18 June 2013

**Our Ref:** 130618PPP-DoPI

**SICEEP – PPP – Hyder storm water response to Department of Planning & Infrastructure comments on redevelopment of the convention, exhibition and entertainment facilities and associated public domain works at Darling Harbour (SSD 5752-2012)**

PROJECT NUMBER	DRAWING NUMBER	REV
AA004399	WP-FL-0212	01

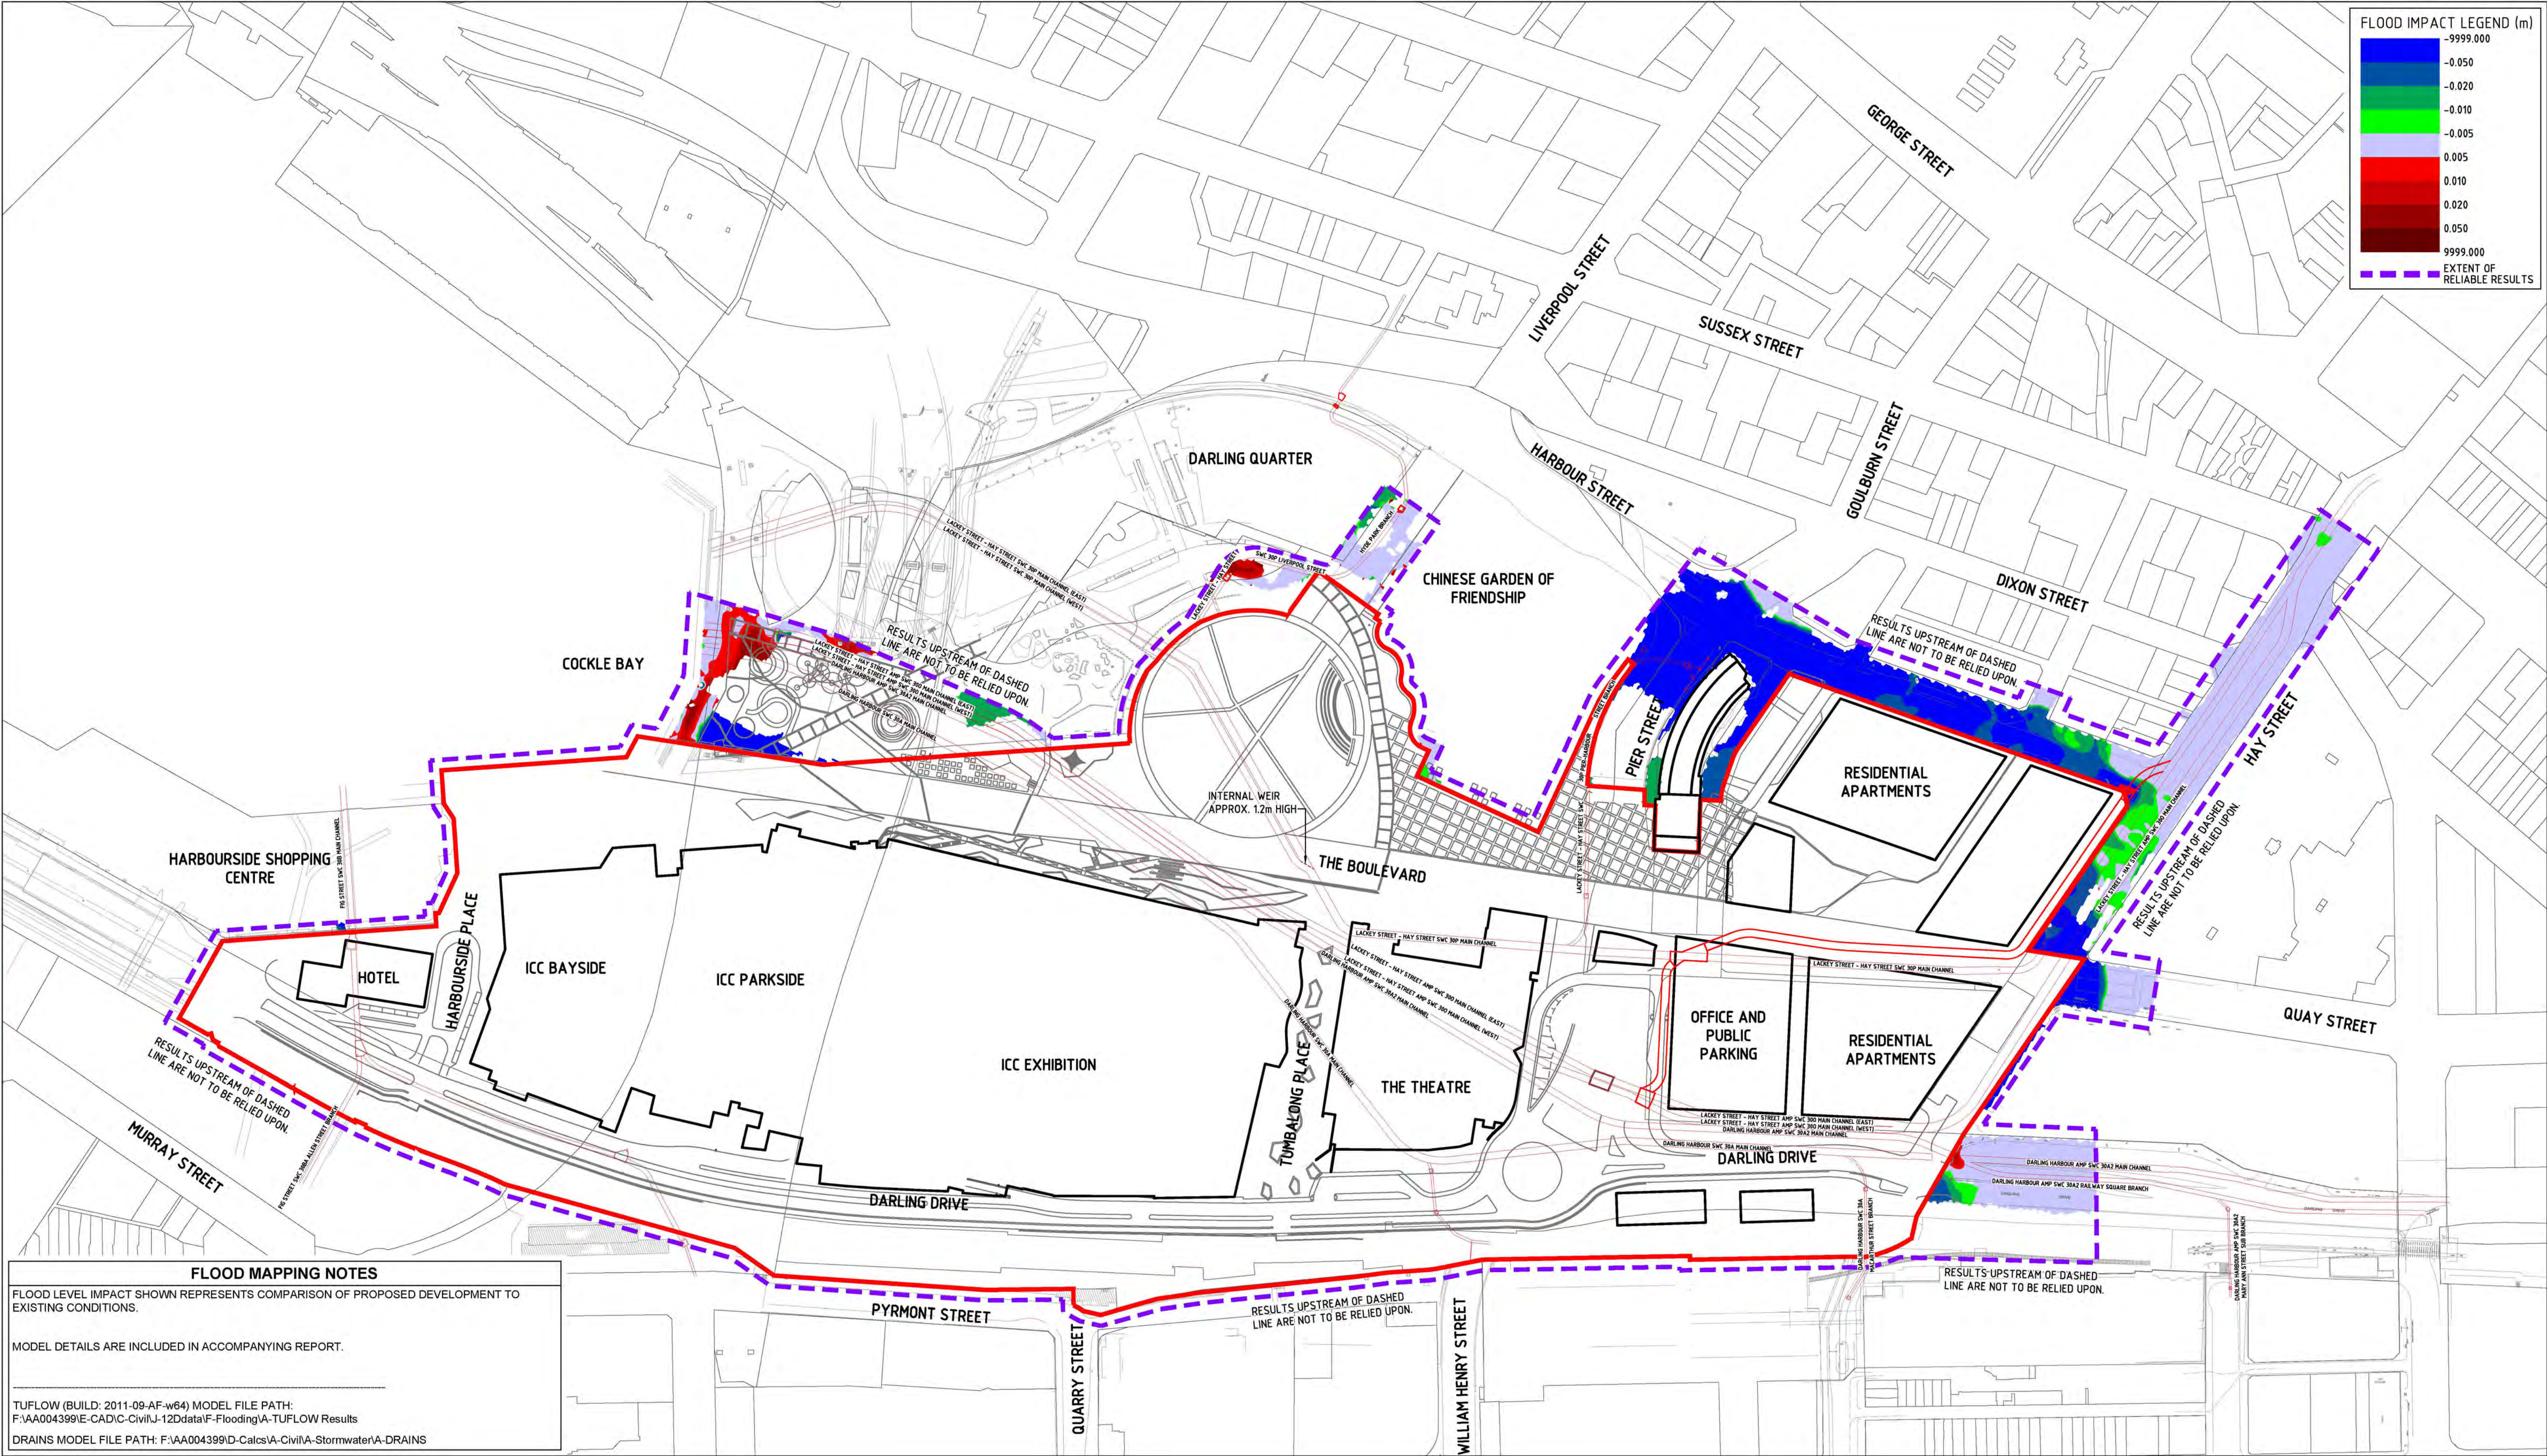
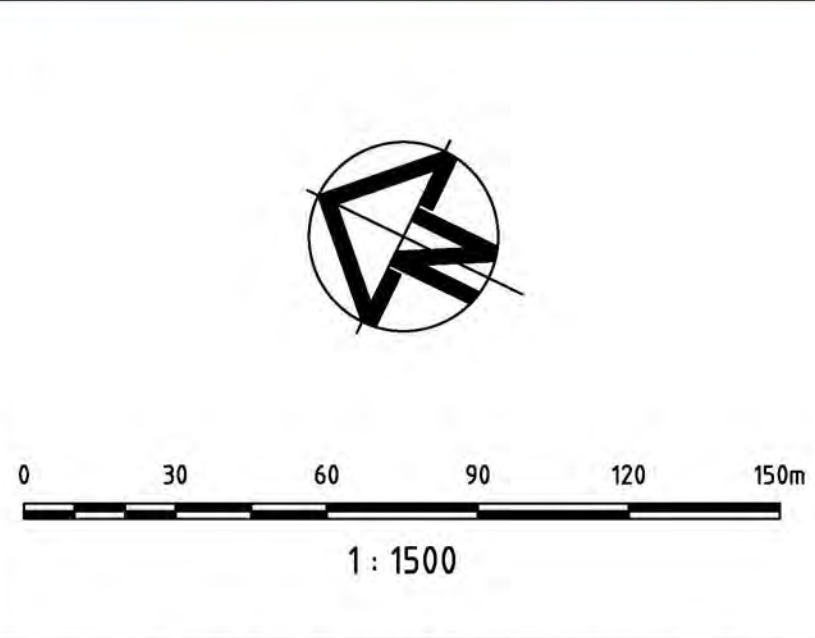
<p><b>Comment 59</b></p> <p>In terms of the potential flood impacts in Section 3.4 further explanation is sought as to the key differences in hydrological and hydraulic representations between the existing and proposed case DRAINS and TUFLOW models.</p>	<p>The key differences between the existing and proposed case DRAINS and TUFLOW models are;</p> <ul style="list-style-type: none"> <li>• Inclusion of concept minor drainage system in the proposed model.</li> <li>• Modifications to the digital elevation model (Including the proposed building ground floor footprints).</li> <li>• Sub-catchment boundary delineation, noting that overall (total) existing and proposed catchment areas are the same.</li> <li>• Amplification option.</li> </ul> <p>All other parameters are consistent in existing and proposed models.</p>

TYPICAL CROSS SECTION - PROPOSED DARLING DRIVE

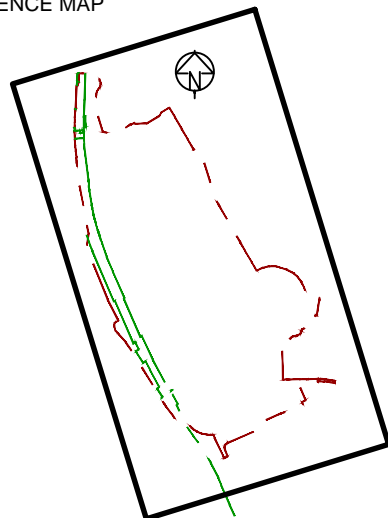
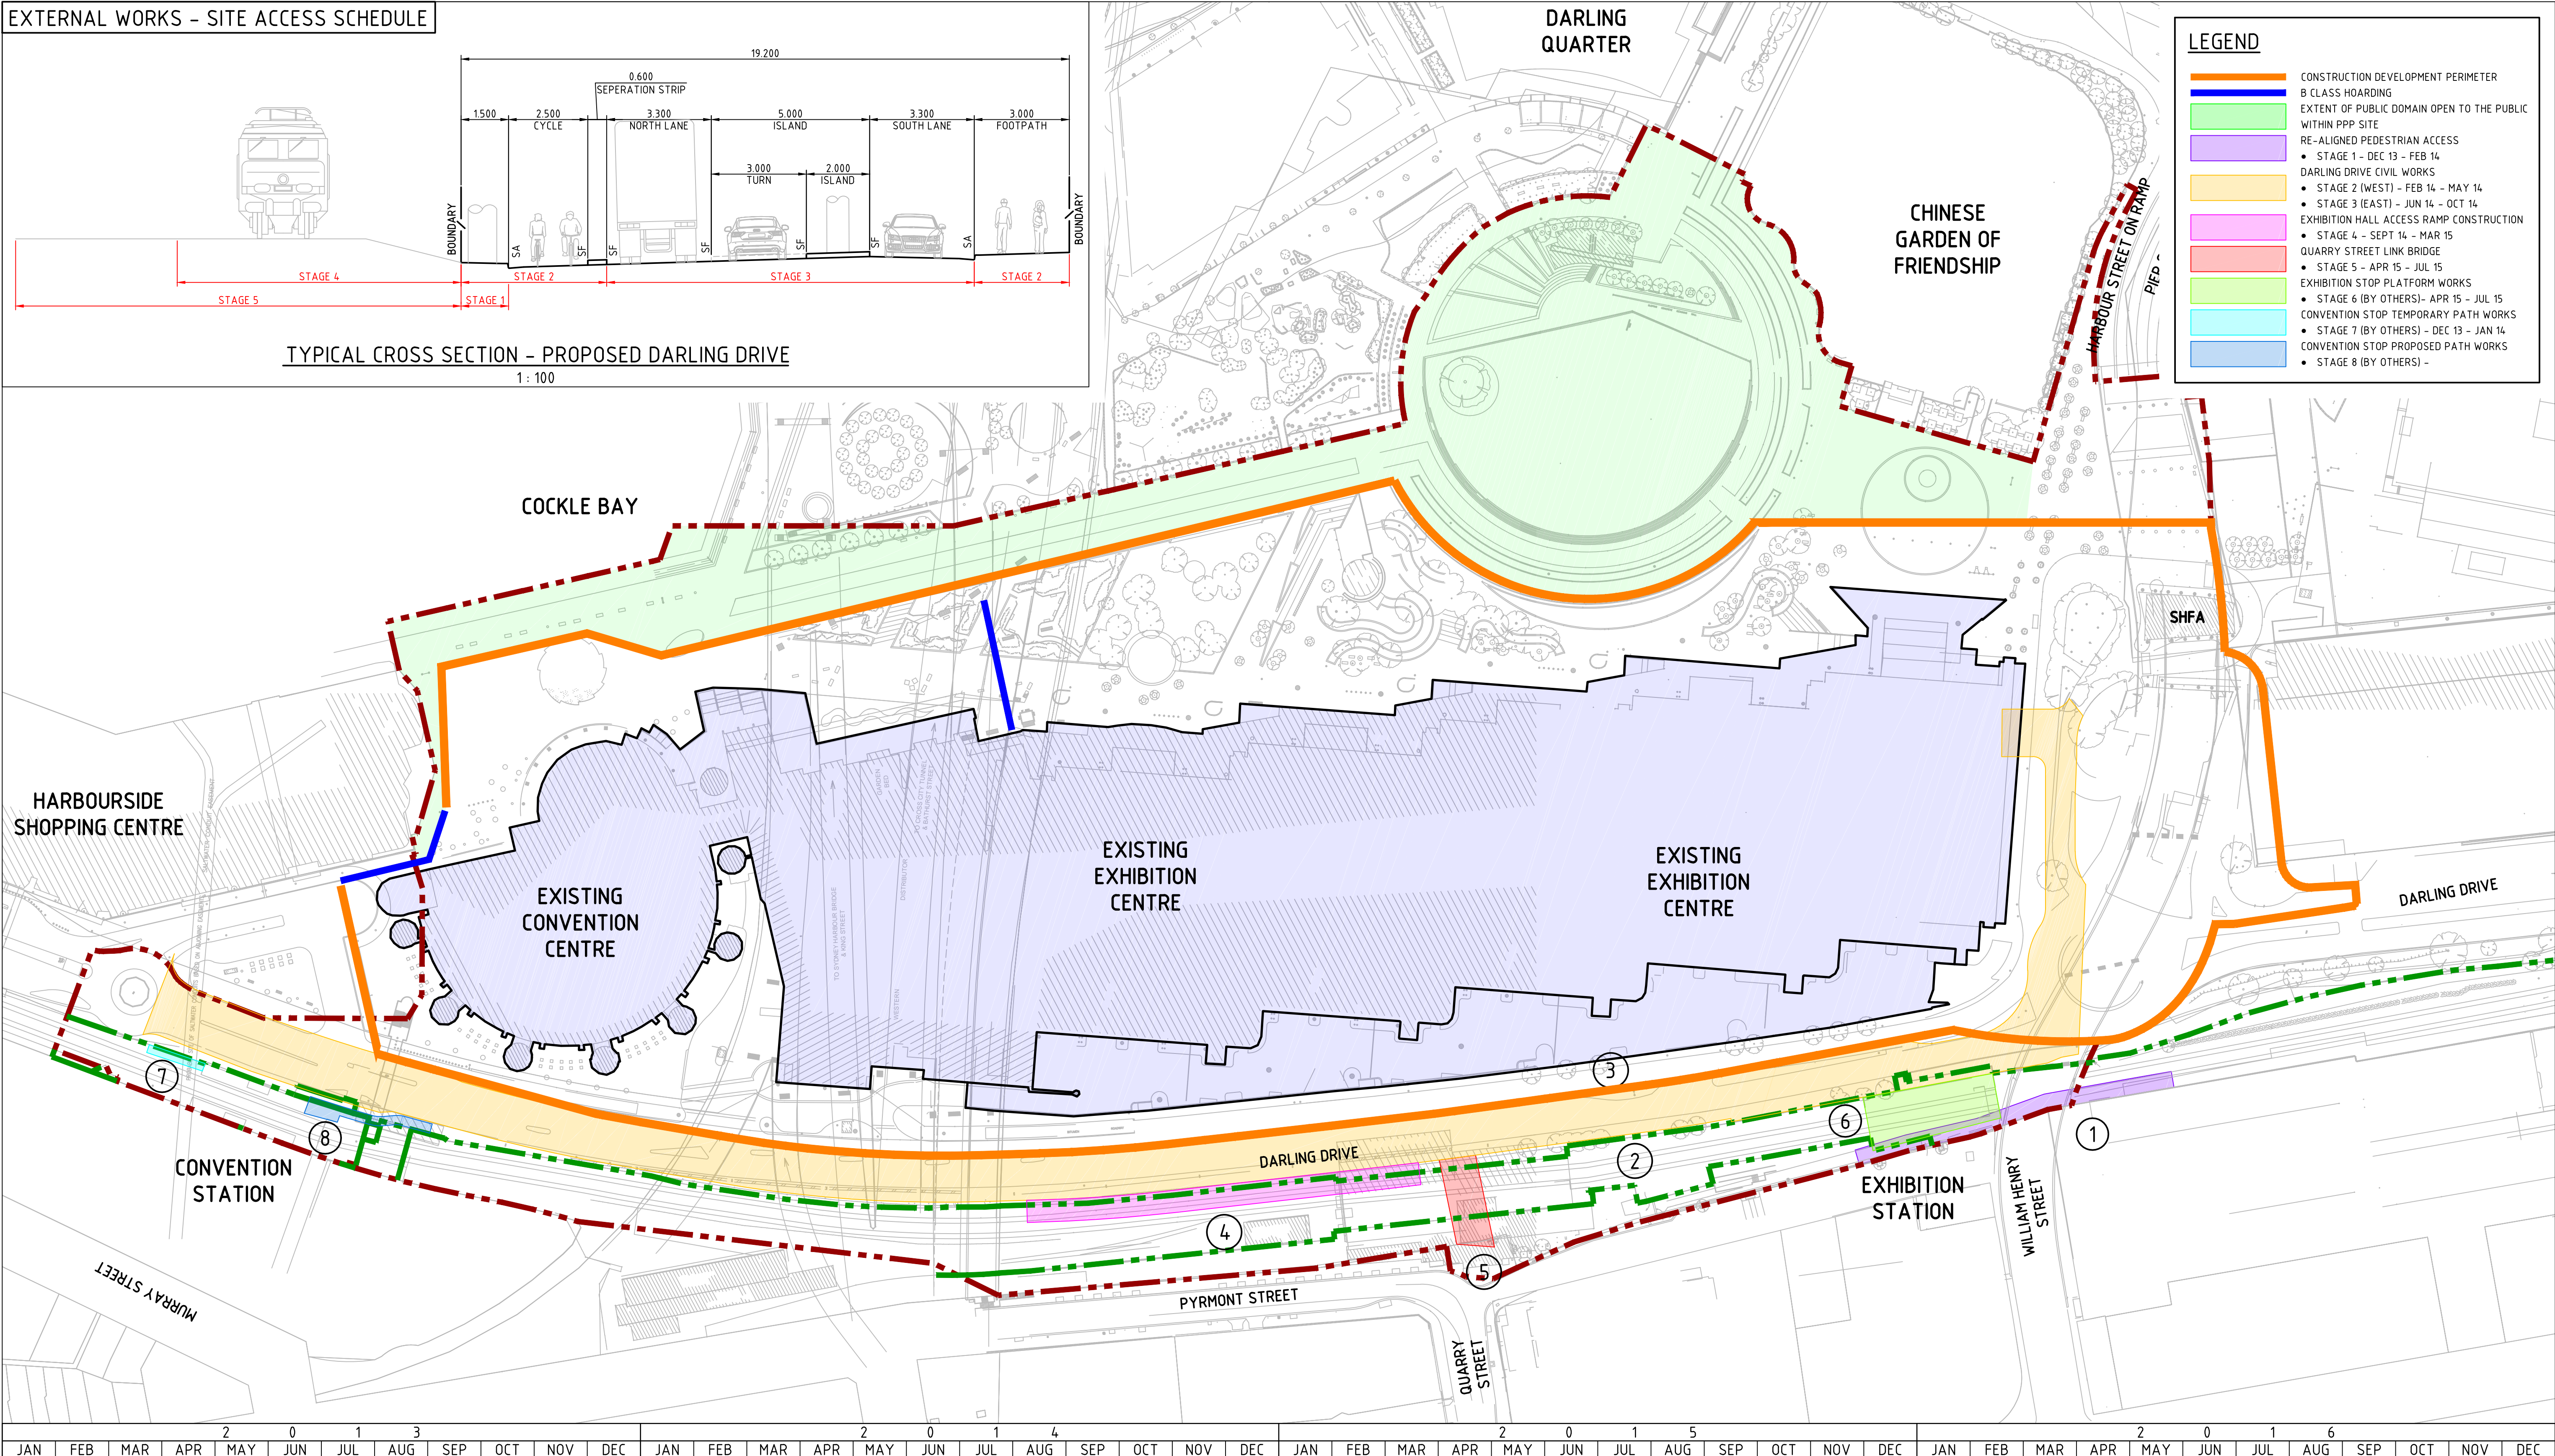
DoPI Comment	Hyder Response
<p><b>Comment 57</b></p> <p>Clarify whether any preliminary concept work been undertaken to confirm whether the opportunities to improve the drainage of surface water conditions along Darling Drive are feasible.</p>	<p>Hyder have completed a concept road design and stormwater design. The improved surface drainage conditions will be assessed during detail design.</p>
<p><b>Comment 58</b></p> <p>The Flooding and Stormwater Report submitted with the EIS states that when adopting a 30% and 50% blockage assumption there are sufficient inlet pits so that the underground system will not be limited by surface inlet capacities. Clarification is sought as to whether the modelling assumes all upstream catchment flows entering the project site are contained within the underground pipe systems with no overland flow component.</p>	<p>Please refer to the response to (56).</p> <p>Catchment flows are not contained within the underground system. The underground systems have limited capacity and the modelling includes overland flows in excess of the underground capacity. The flood mapping provided is considered adequate to address this comment.</p>
